From: Ross Leal
Sent: 17 July 2015 16:50
To: [REDACTED]
Subject: RE: R/155/15/HH - 55 Mallon Dene, Rustington

From: Ross Leal
Sent: 17 July 2015 16:49
To: [REDACTED]
Subject: R/155/15/HH - 55 Mallon Dene, Rustington

I refer to my conversation on site with Mrs Sibley on 16 July 2015.

FRONT ELEVATION

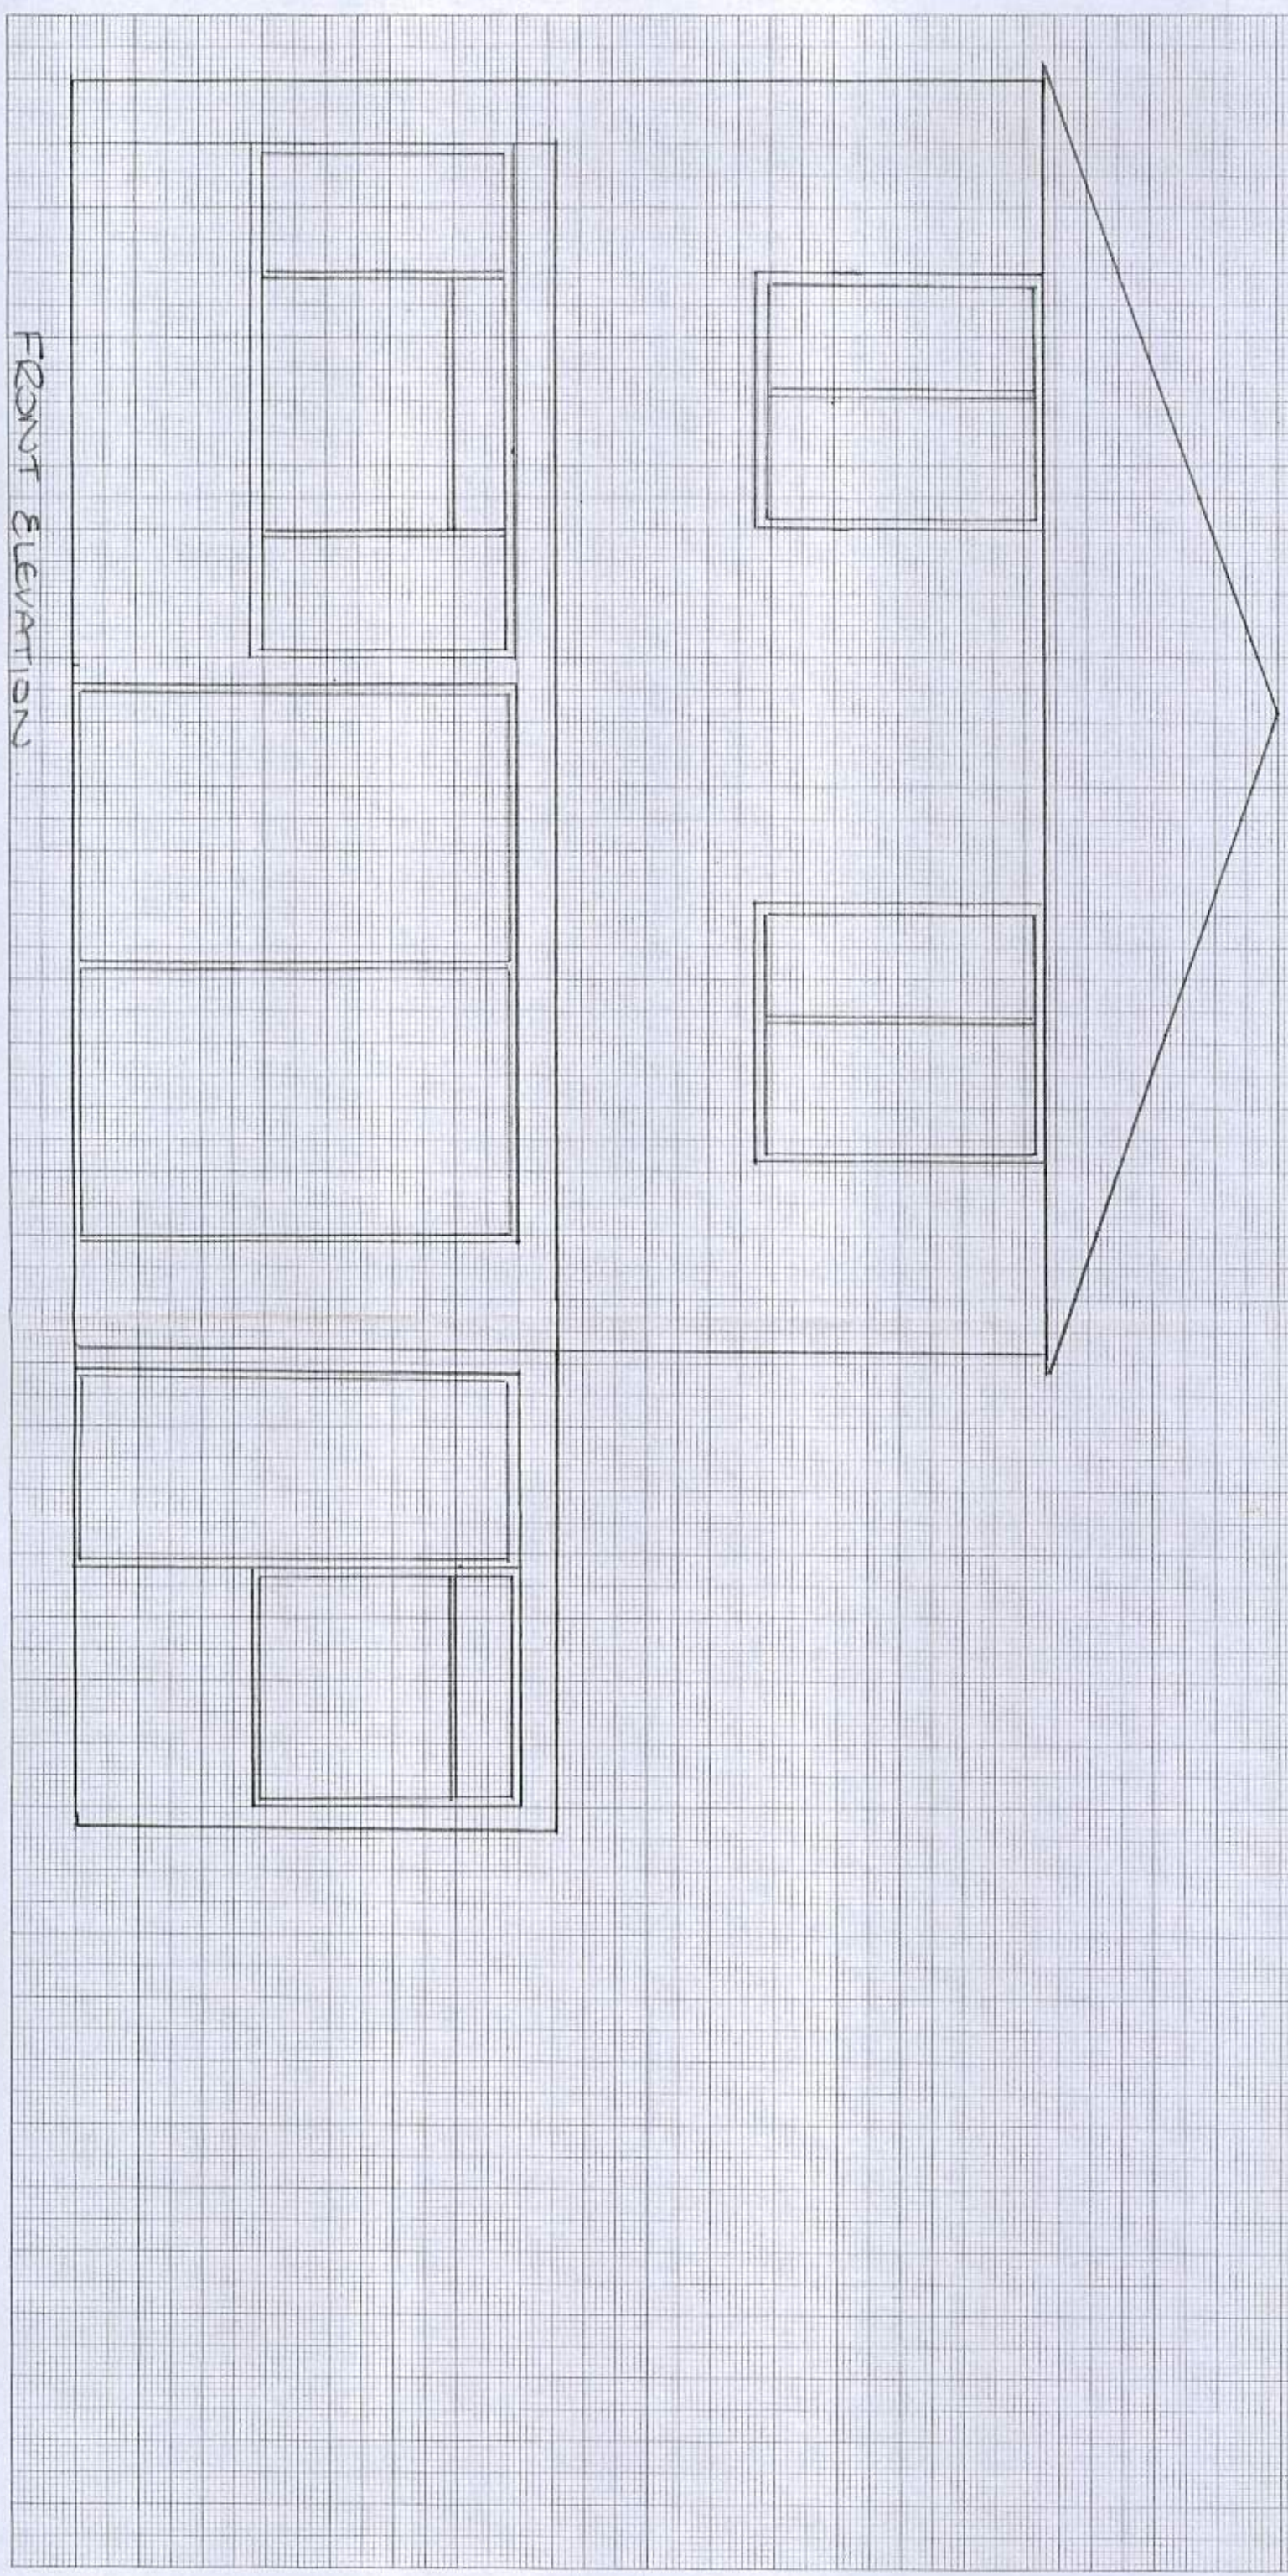
As discussed, I believe there is some merit in considering the addition of a sloping roof above the existing flat roof and proposed front extension. We would expect a sympathetic design and can also the roofing material should match the existing in colour and profile. If at all possible, any tiles used should also match the existing as closely as possible. I would suggest a low pitch to the roof slope also.

I can confirm that it is my view that the house need not be required to match those around it in terms of its appearance, as long as what is proposed is not incongruous or intrusive in the street scene. Indeed, it might be argued that your proposal (subject to seeing details) results in an improved appearance – an might encourage others to consider something similar.
